CITY OF PORTLAND BUILDING PERMIT

Located At 115 BRADLEY ST

Job ID: 2012-04-3869-ALTR

has permission to build a two story addition (Single Family Residence).

A3

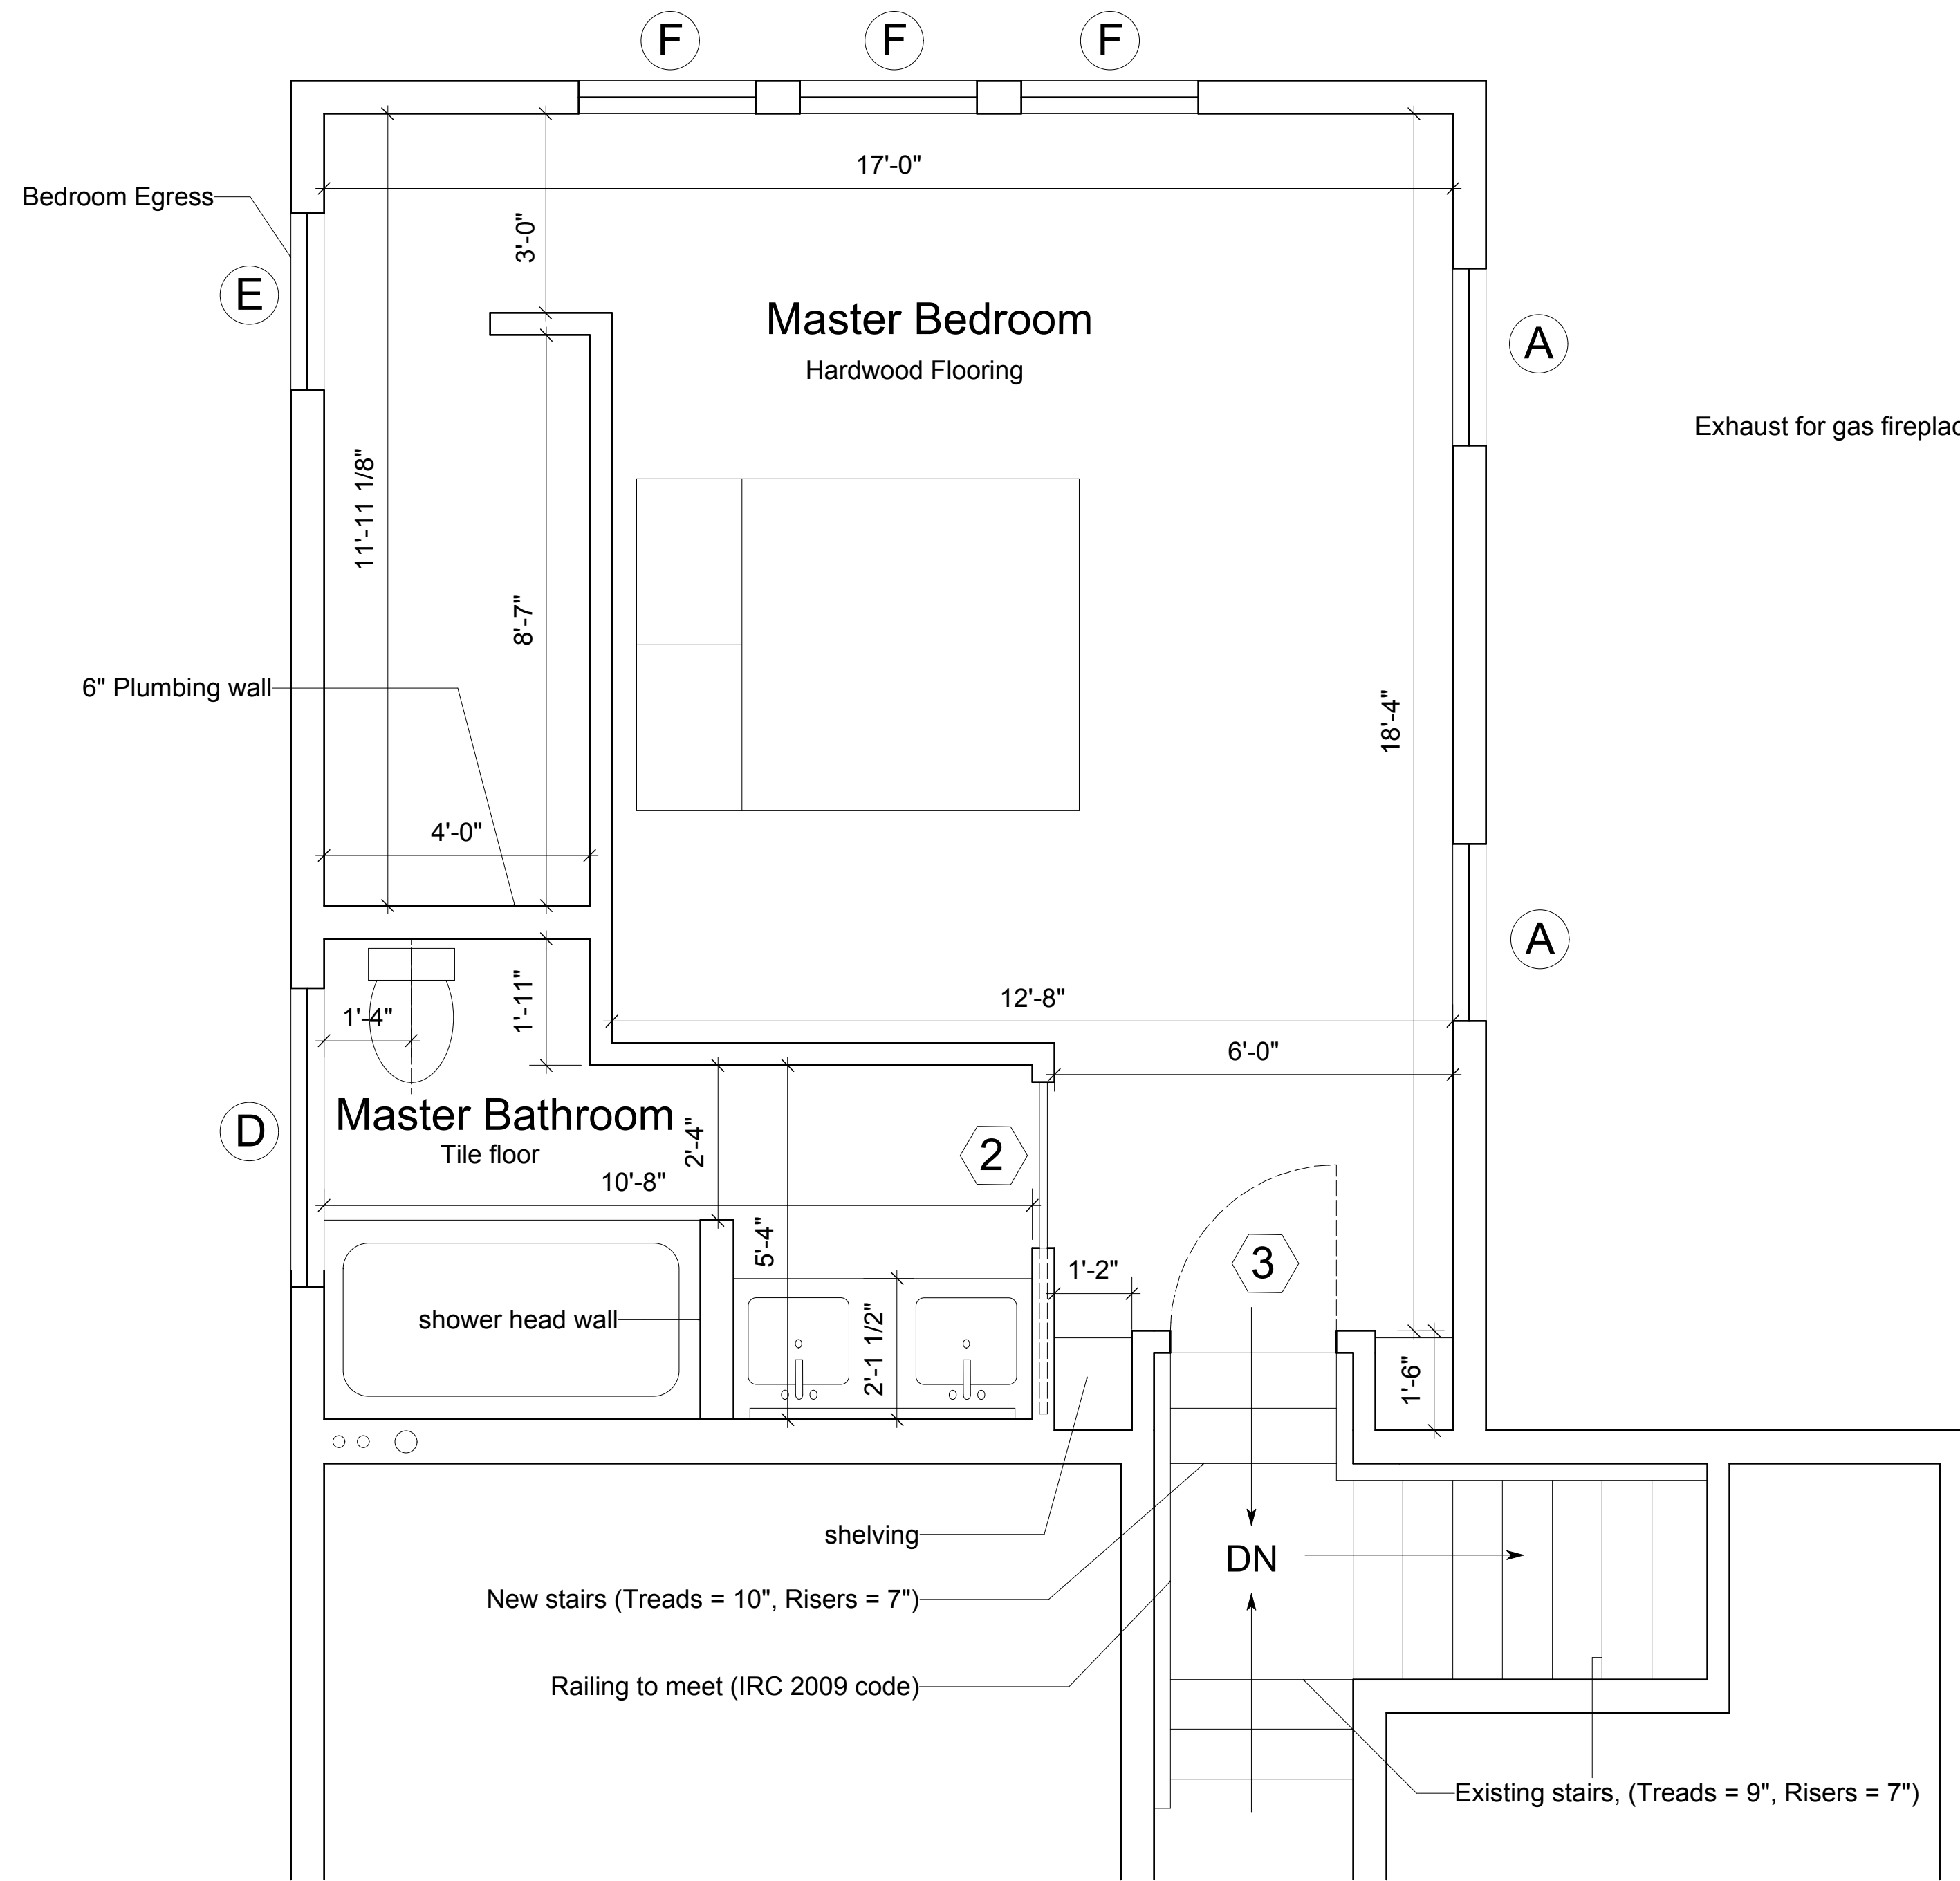
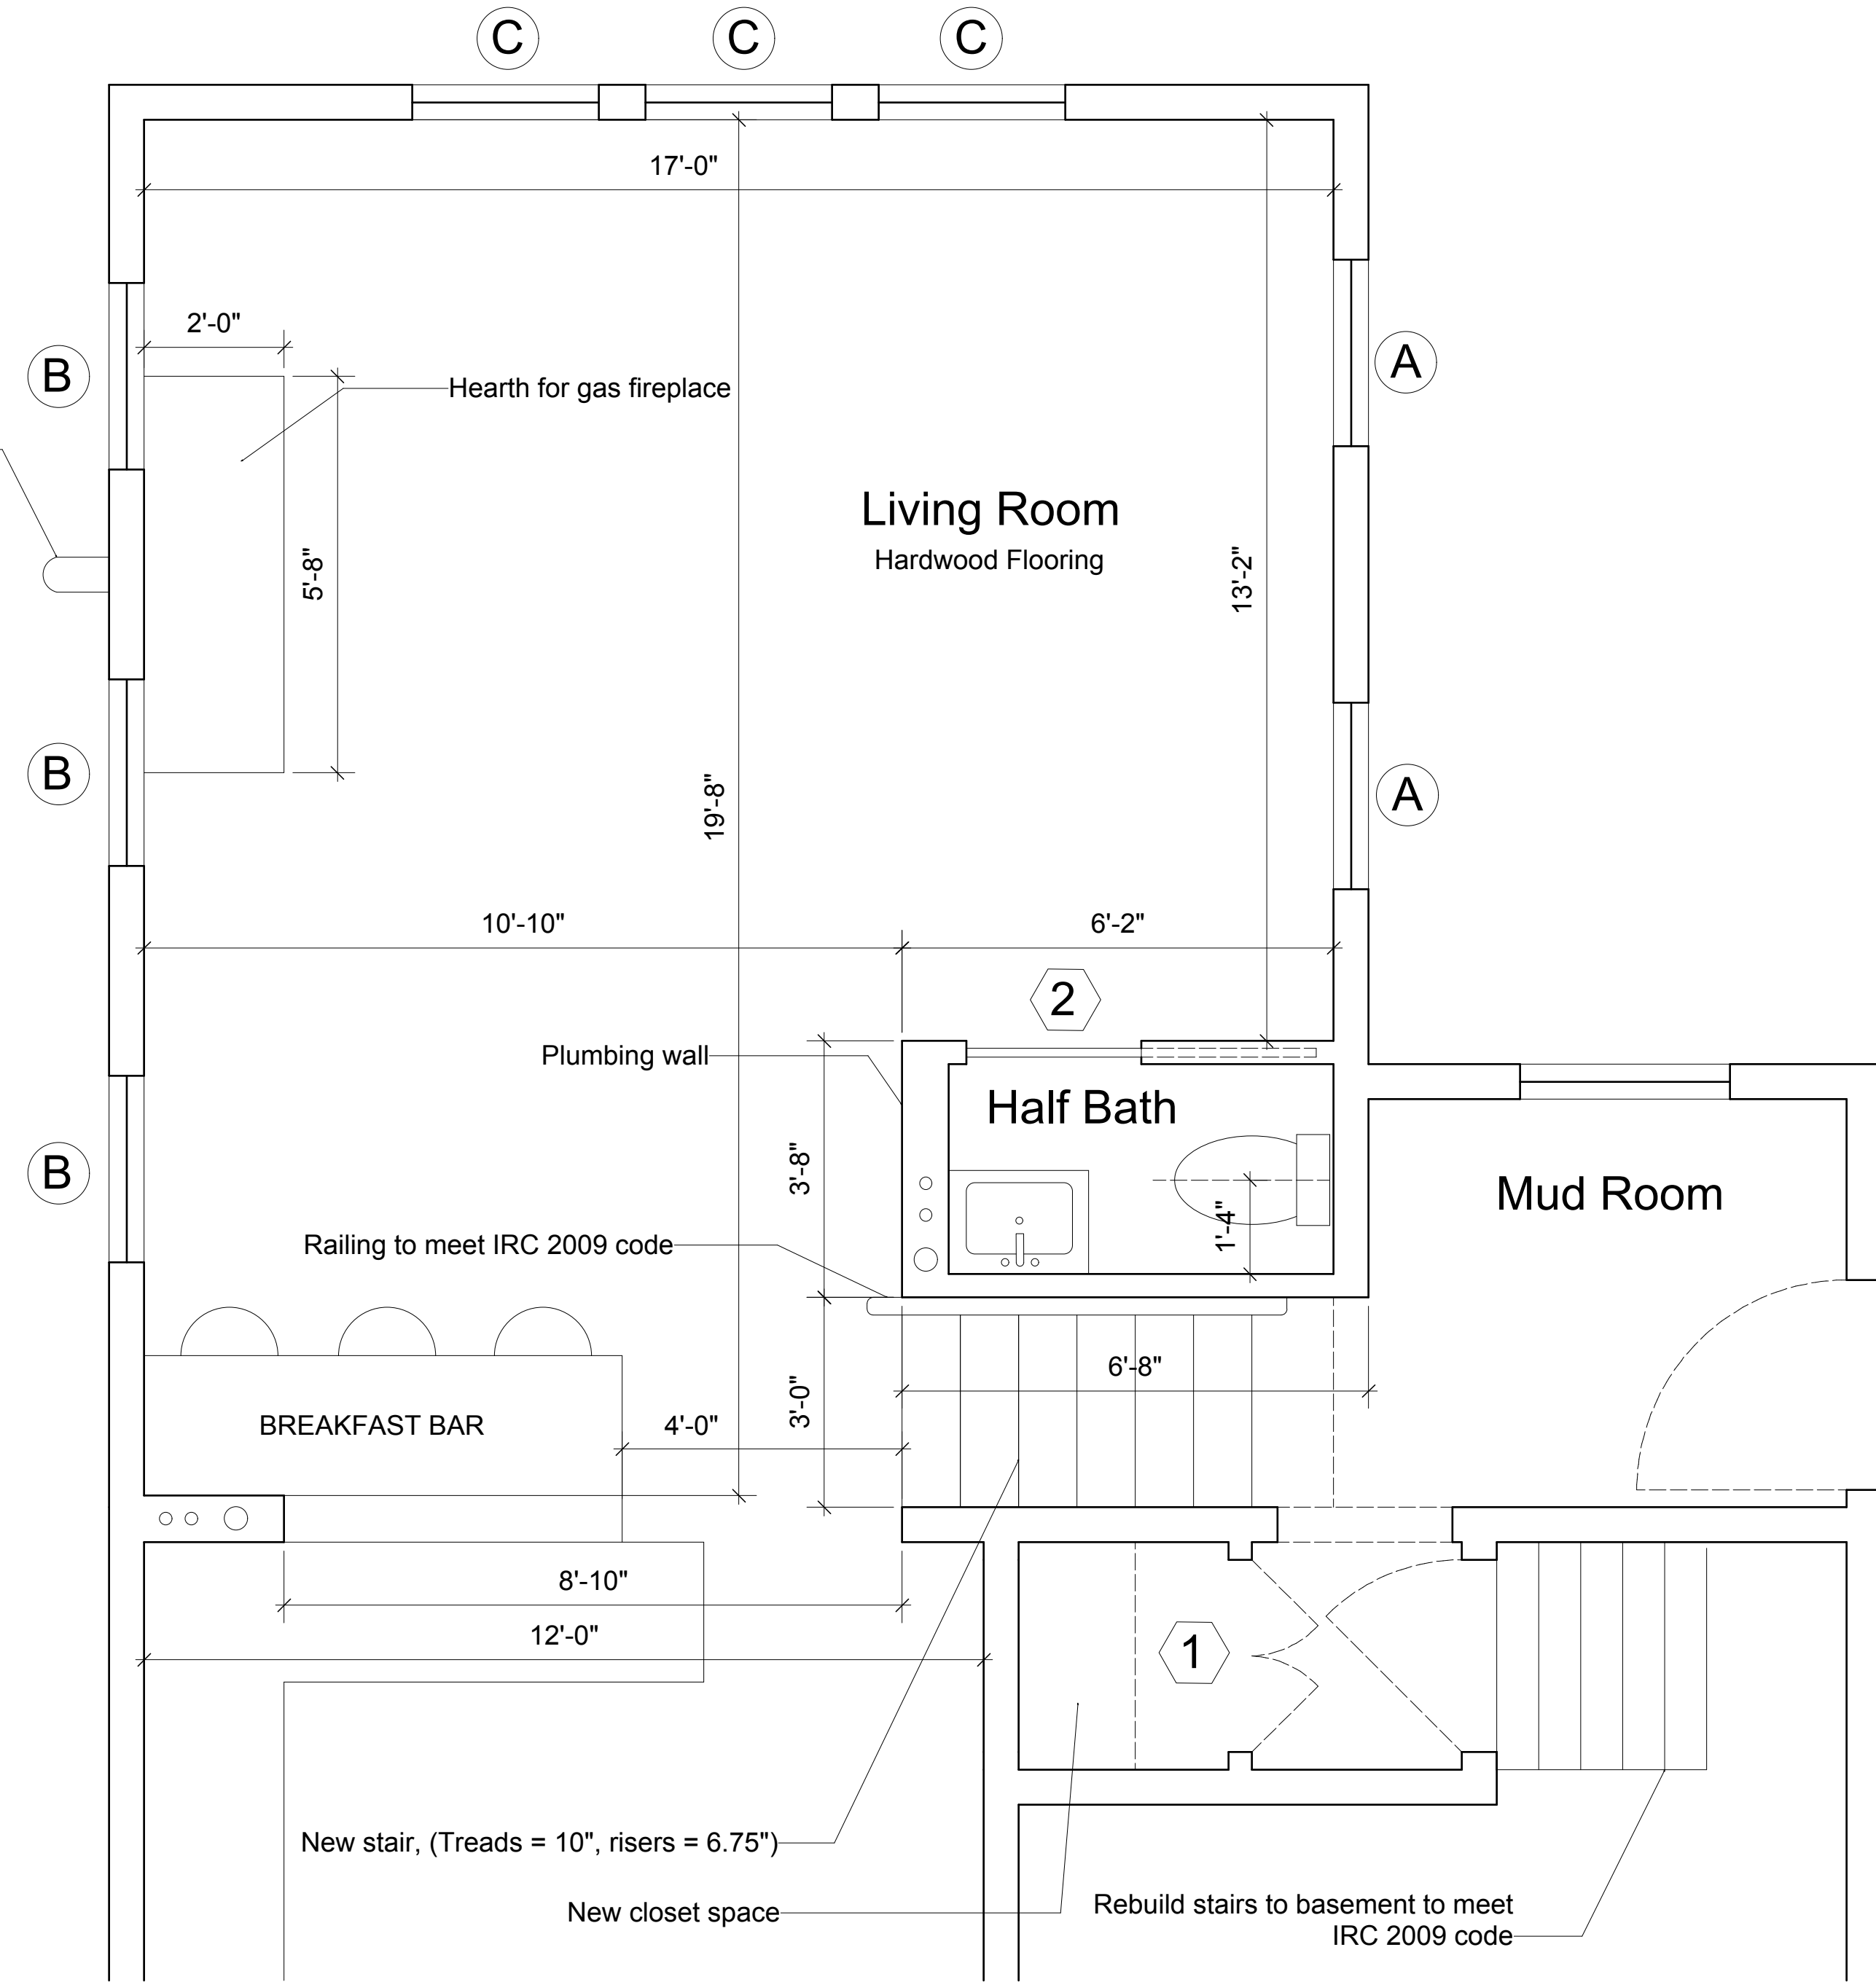
8. Mechanical or natural ventilation is required in the bathroom.
9. A code compliant emergency escape shall be provided in each bedroom. Window sills in locations more than 72 inches from finished grade shall be a minimum of 24 inches (no higher than 44 inches) above the finished floor of the room, or in compliance with Section R612.4.2 Operation for emergency escape.

- a. Note: Contractor is the moving master bedroom egress window to avoid closet obstruction.
